From: [REDACTED]
Sent: 14 May 2026 16:06
To: Planning
Subject: Formal Objection – Planning Application 3/2026/0287
Attachments: 7253.jpg; 7254.jpg

Re: Formal Objection – Planning Application 3/2026/0287
Proposed extension of industrial unit from 296m² to 916m²
Original appeal approval reference: 3/2015/0159

**2 Site Plan**  
1 : 500

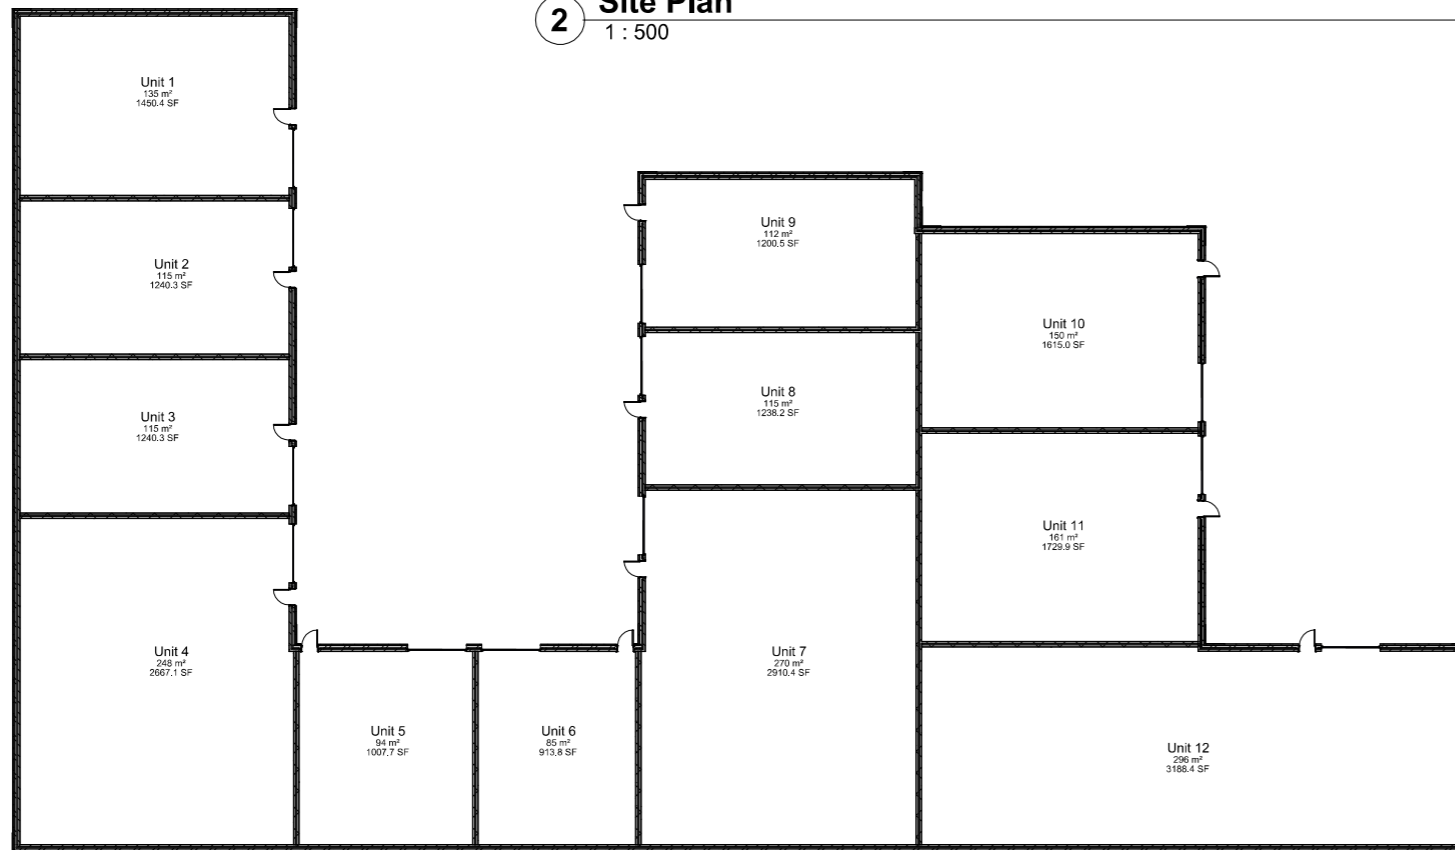
The submitted "current site plan" does not appear to accurately reflect what has actually been constructed on site.

More importantly, it avoids direct comparison with the plans originally approved under application 3/2015/0159.

Areas originally approved as landscaped planting and permeable surfaces now appear to have been converted into hardstanding.

- an accurate current topographical/site layout plan;
- a comparison drawing showing approved vs existing layout;
- clarification regarding any unauthorised works undertaken.
